Transport Note

Subject: Review of Transport Planning Statement for AL/70/11
Site: Woodgate Centre, Oak Tree Lane, Woodgate
Prepared by: Fiona Thorp, Transport Planner
Checked by: Phil Bell, Director
Date: 10th October 2011

Client				Builtform Developments Limited			
Project				Woodgate Centre, Woodgate			
Drawing Title				16.5m Max Legal Length Articulated Vehicle Accessing and Egressing Site			
Scale	1:500	Drawn By	KFM	Checked By	SAJ	Approved By	CMB
Drawing No.	2011/1307/103	Date	Apr 2011	Rev.	-

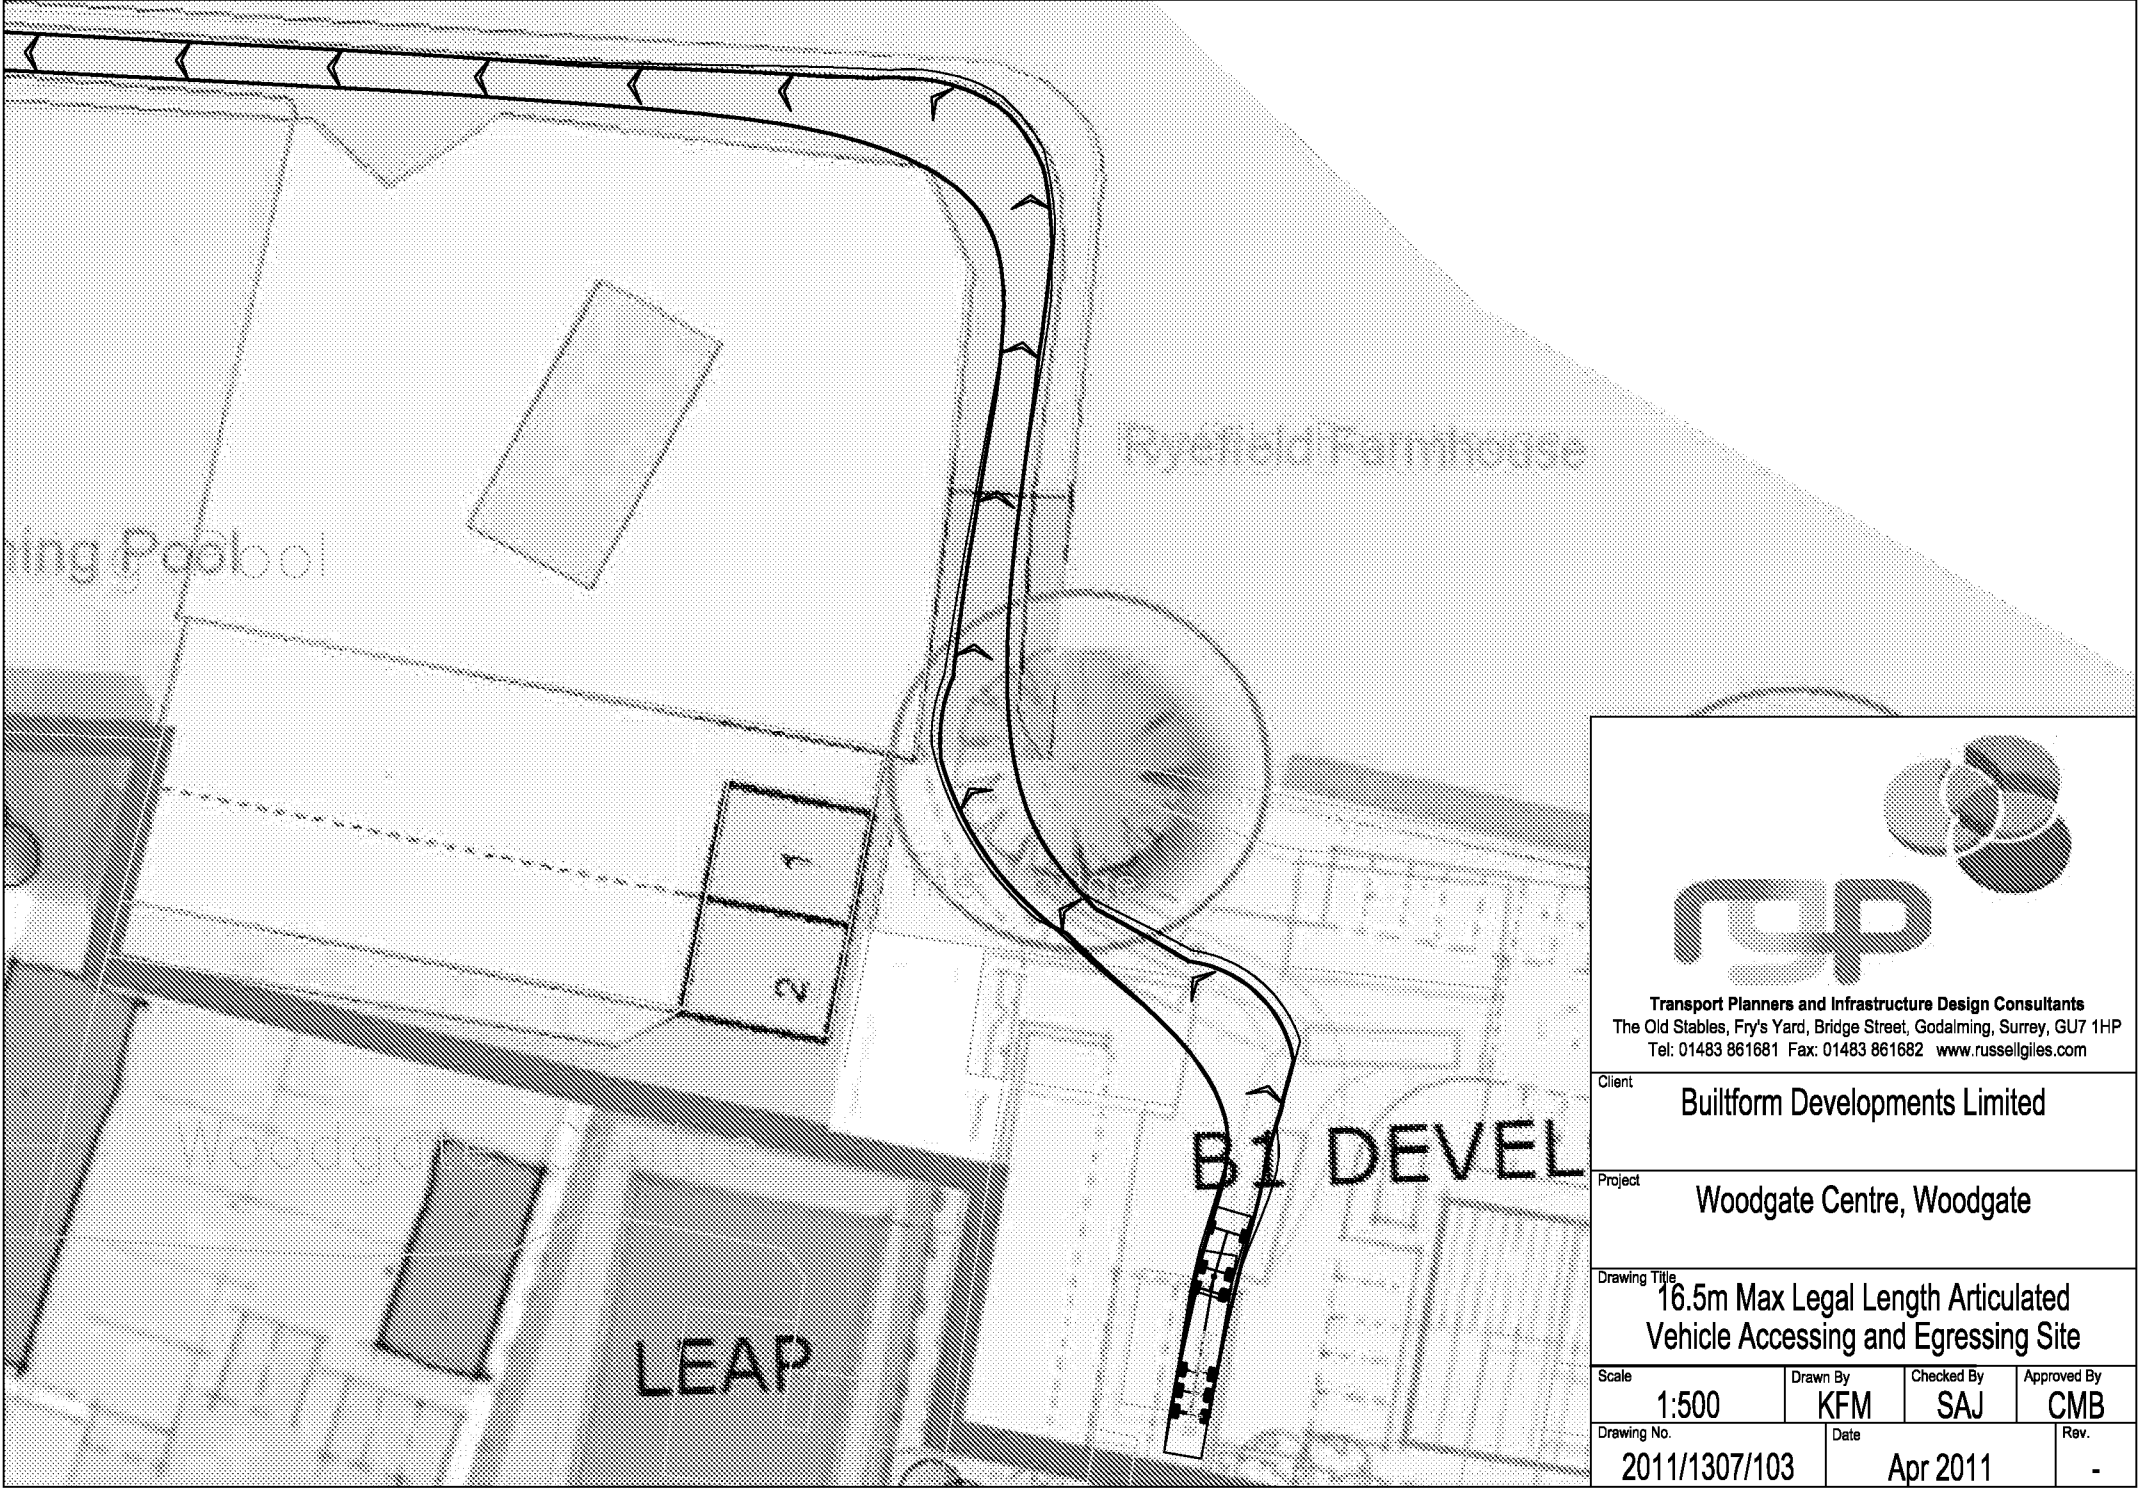
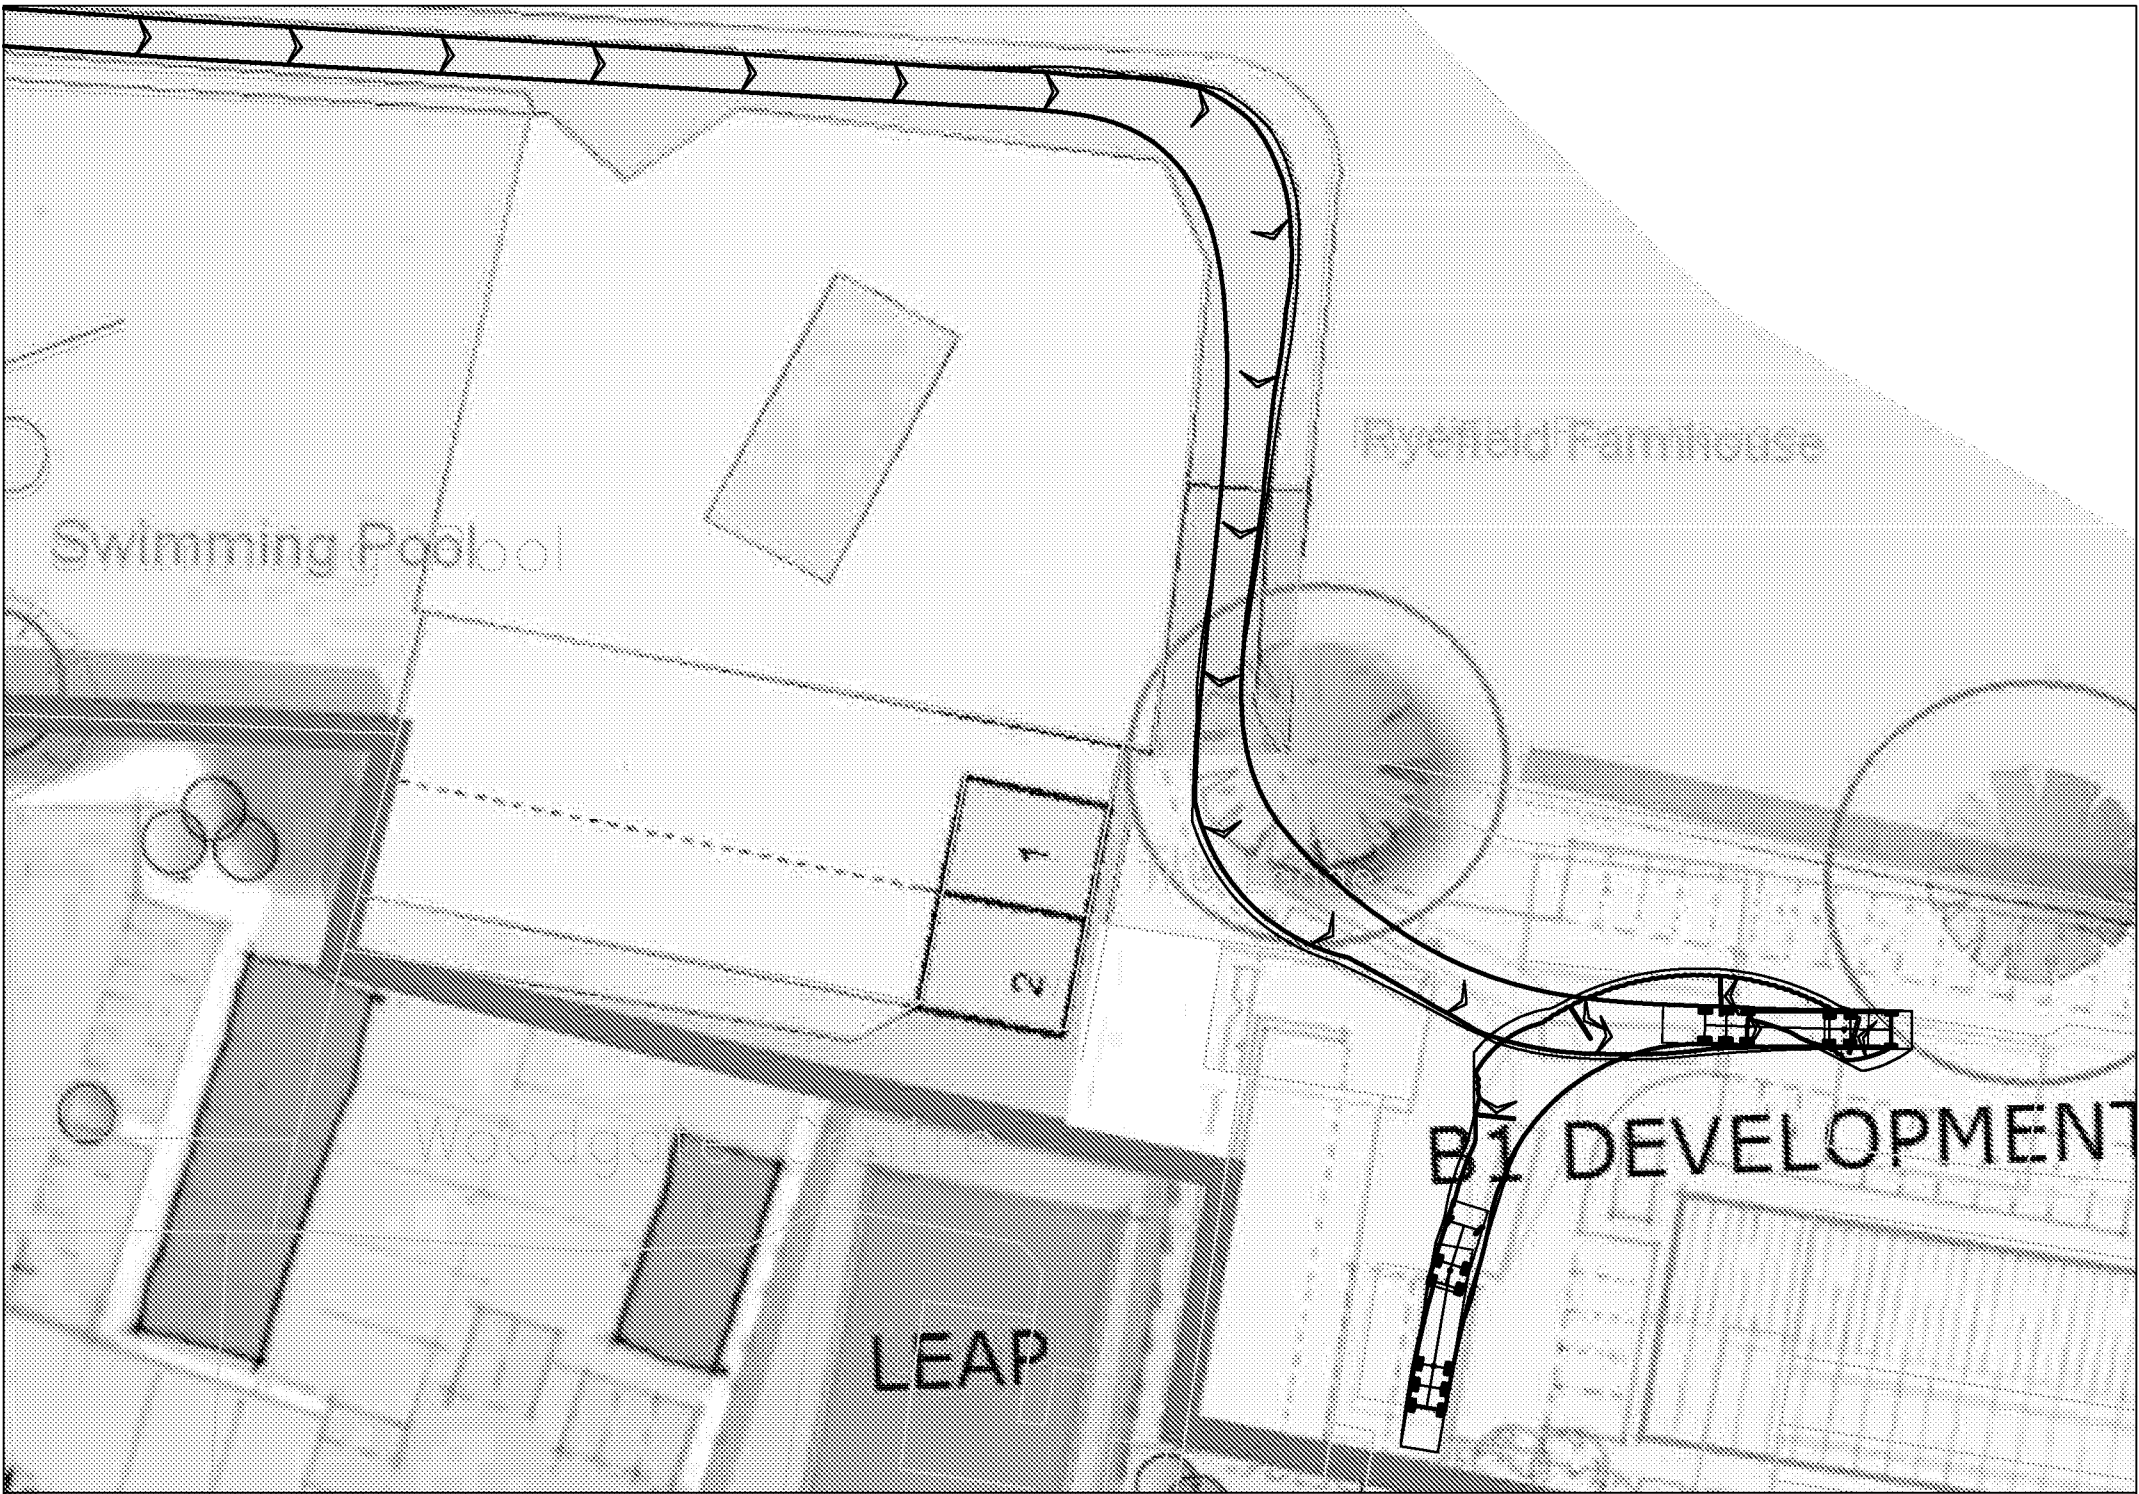
- 3.7** It is understood that Oak Tree Lane is 5.5 metres wide. However, whilst the Transport Planning Statement includes swept path analyses for a 16.5 metre articulated vehicle accessing and turning within the site via Oak Tree Lane and the private access road, this does not appear to demonstrate that the access road is sufficiently wide to accommodate two-way vehicular traffic.

- 3.8** An increase in traffic using the existing access road could to increase the opportunity for vehicular conflict along the road. In particular, there are limited opportunities for passing, which could result in vehicles reversing along the access road, potentially long distances.
